Date: 22 July 2013  
Our ref: 90224  
Your ref: 3/2013/0357

**Planning consultation:** Proposed Windturbine at Huntroyde Farm  
**Location:** Land north of Huntroyde Home Farm, Huntroyde West, Whins Lane, Simonstone.

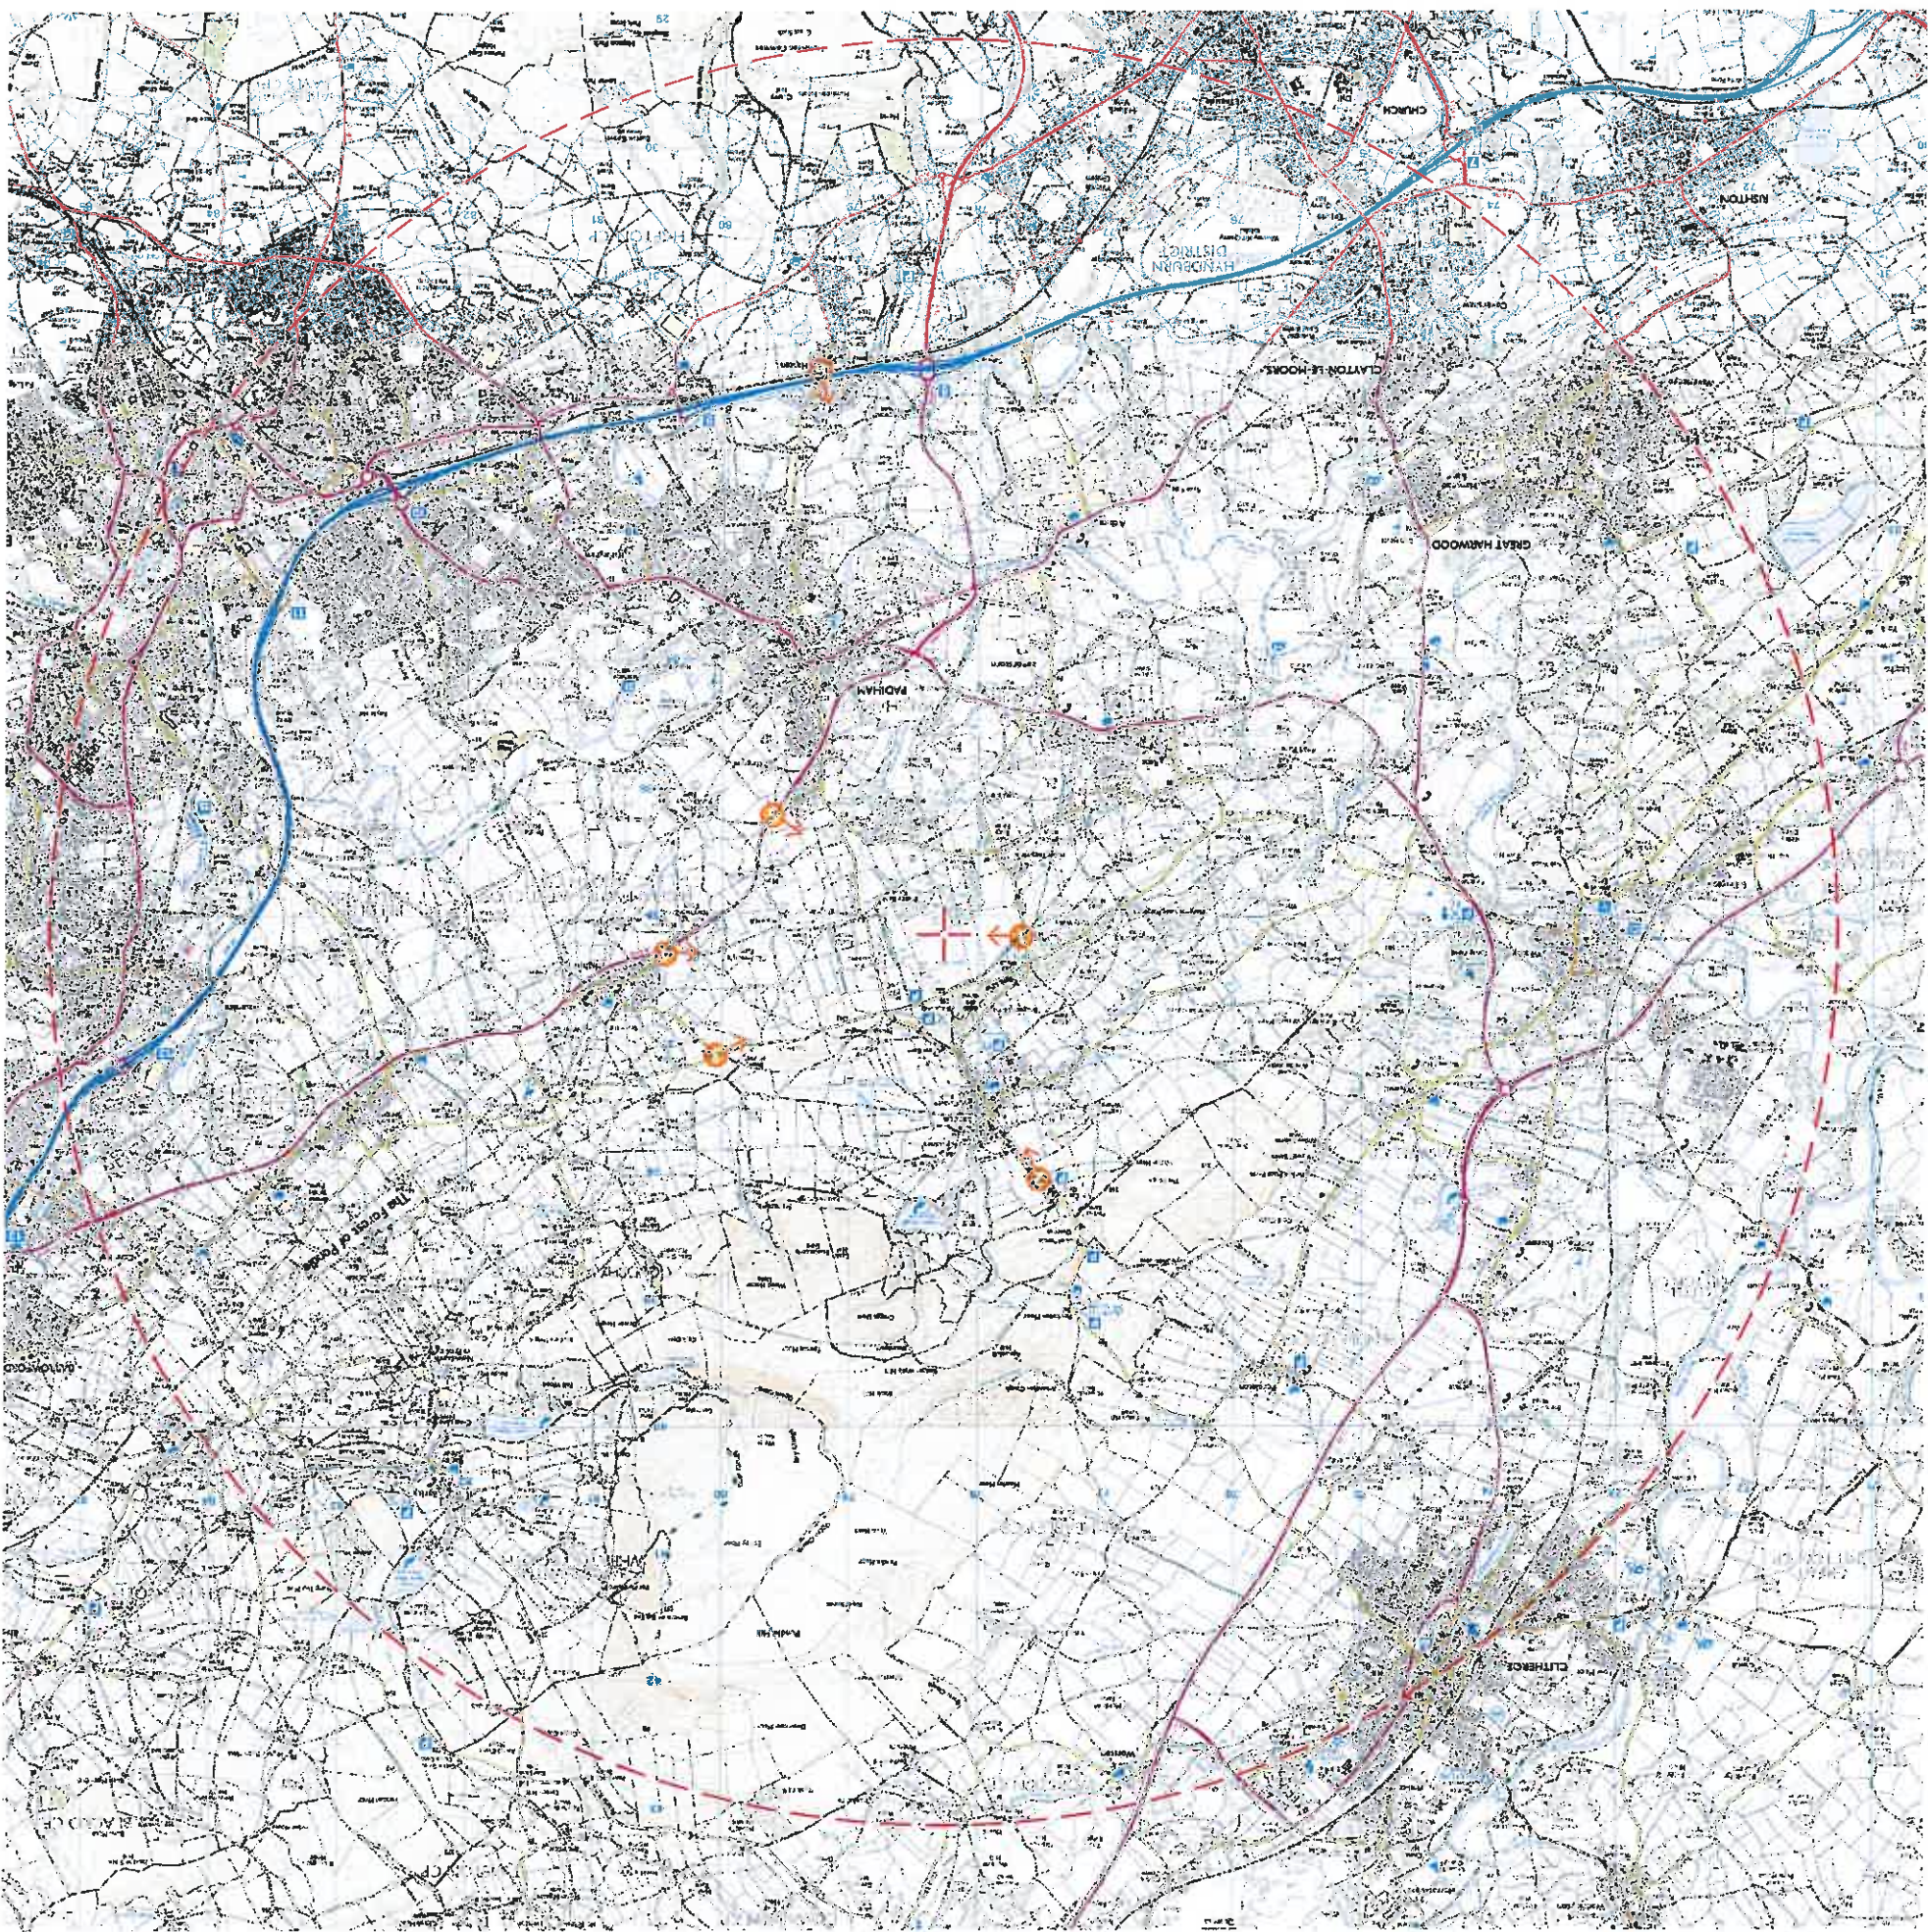
The comments referring to a number of Local Authorities having adopted a 7km radius for visual impact does not provide us with sufficient evidence that this study area size is adequate to assess the visual impact of the turbine on the Forest of Bowland Area of Outstanding Natural Beauty (AONB). It is important to note that applications in different locations will have different impacts due to topography, landscape character, levels of visibility, landscape tranquillity etc. Such a small radius means that the visual impact on elevated areas to the north and north west of the site, which have iconic viewpoints from the AONB and are a key characteristic of the protected landscape, is not being properly assessed. The limited radius used in the LVIA therefore fails to demonstrate that the visual effects of the development will not cause harm to the character of the AONB and its special qualities.

project title	N160: Huntroyde
figure title	Viewpoint 2: Nick of Pendle,
figure reference	Clitheroe Road
scale	N160-GR-LVIA-015
date	February 2013

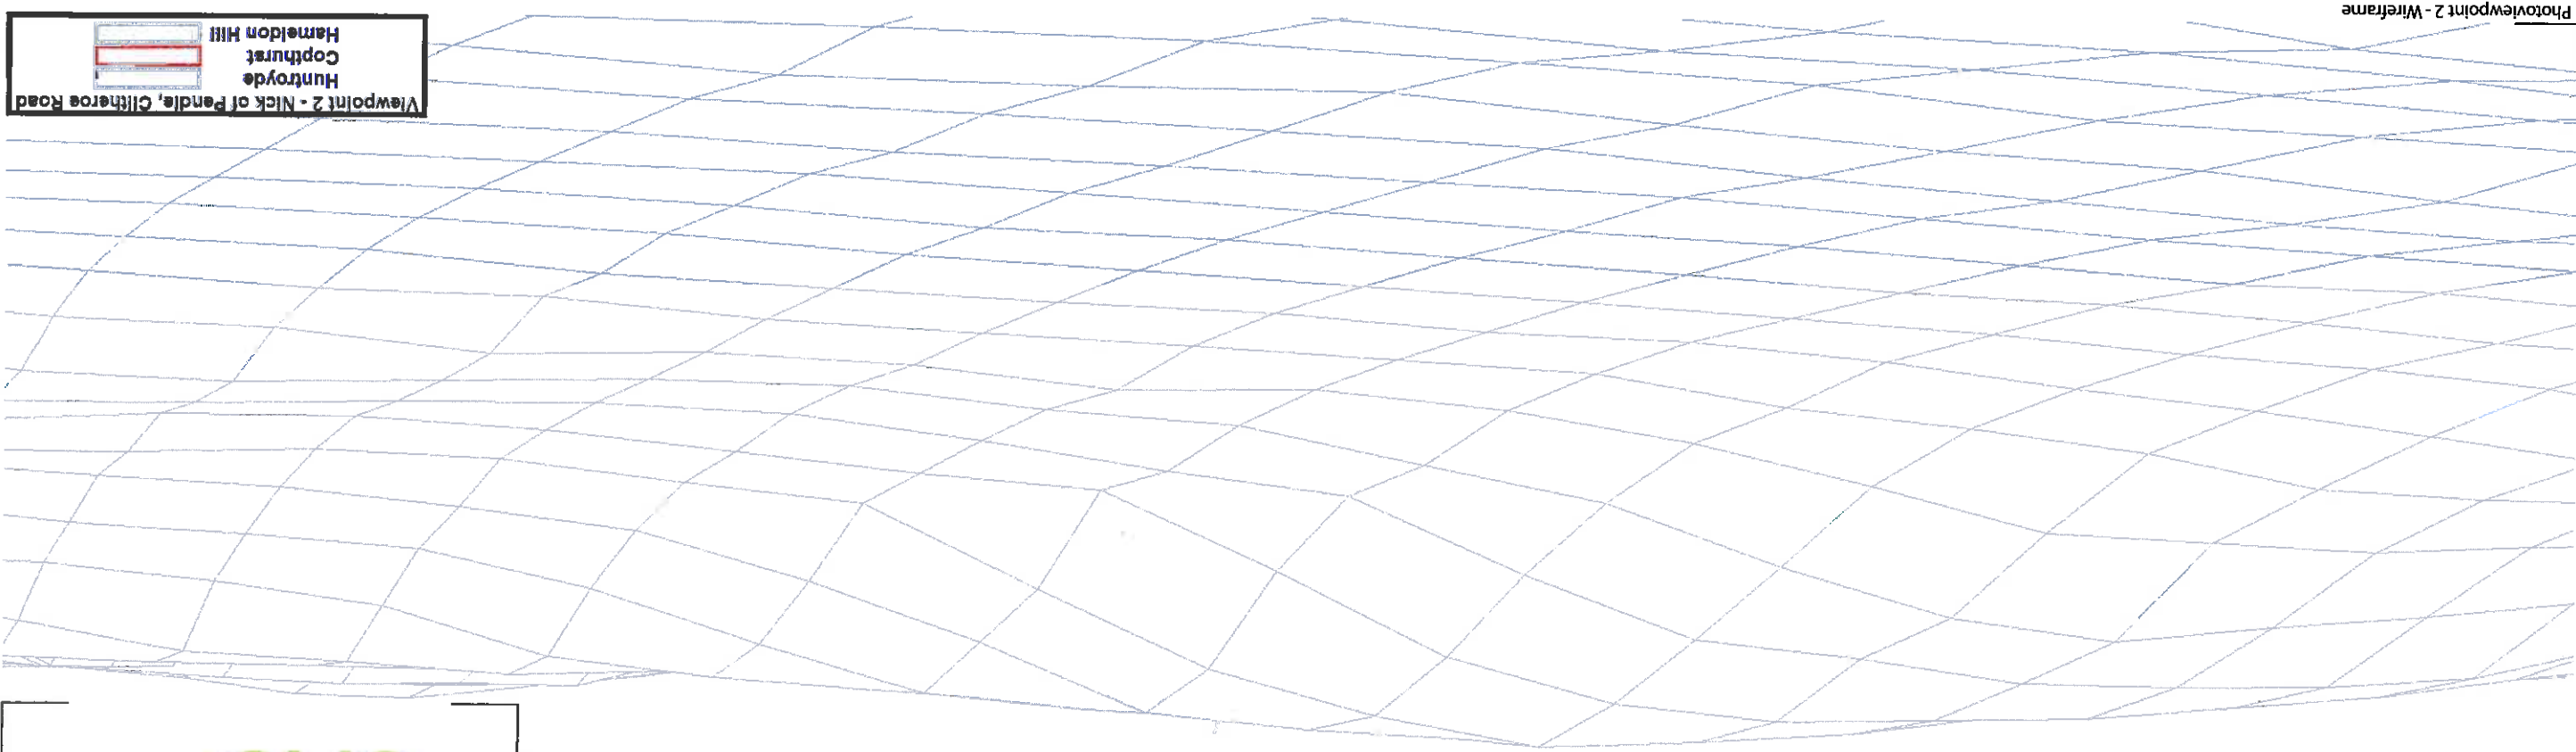
Natural England welcomes the revision to the ZTV to include viewpoint 2a. We agree that the turbine would be partly screened by the coniferous woodland; however we are still concerned that further viewpoints have not been chosen further north and upslope from the turbine from which views will not be screened by the coniferous woodland.

Viewpoint 3 - Stump Hall, Stumphall Road
Huntroyde
Copthurst
Hameldon Hill

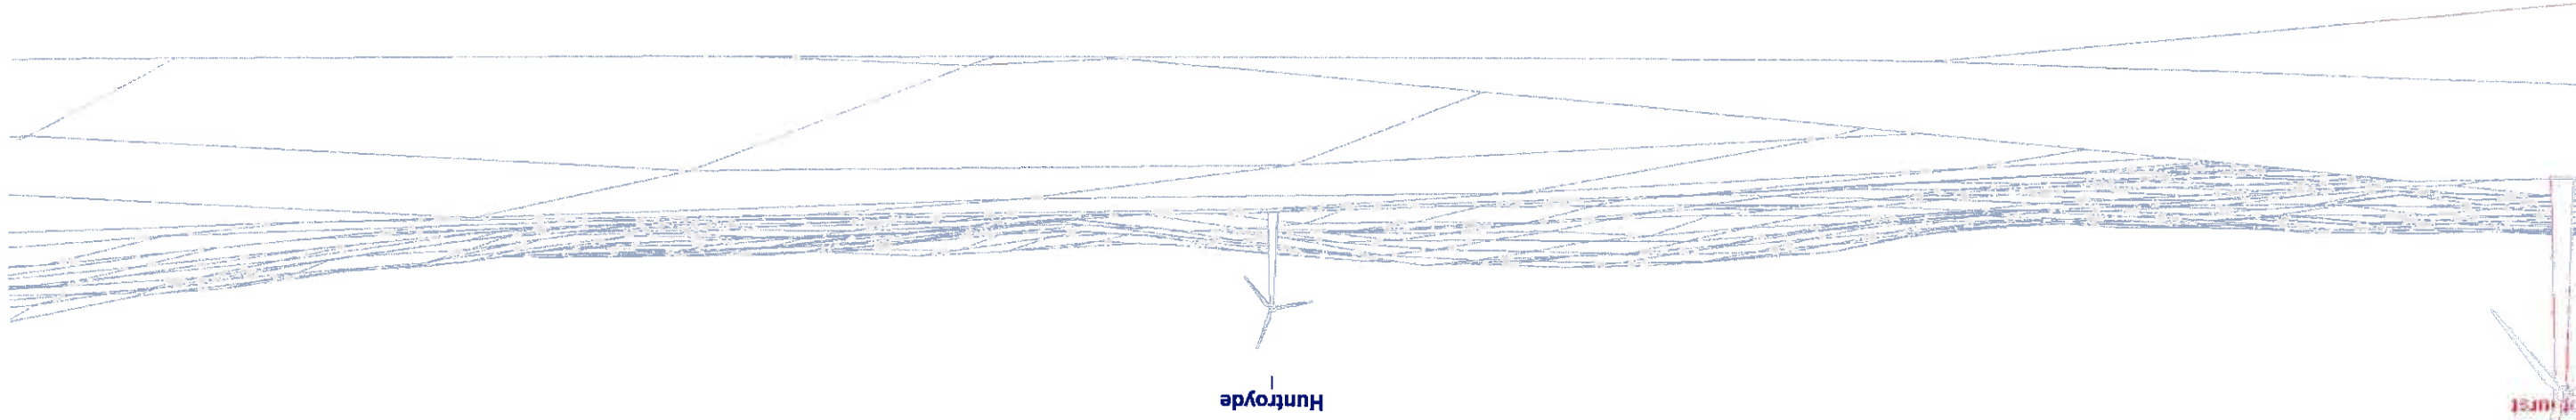
Natural England are still of the same view that we consider the magnitude of change at VP3 to be 'medium' not low.
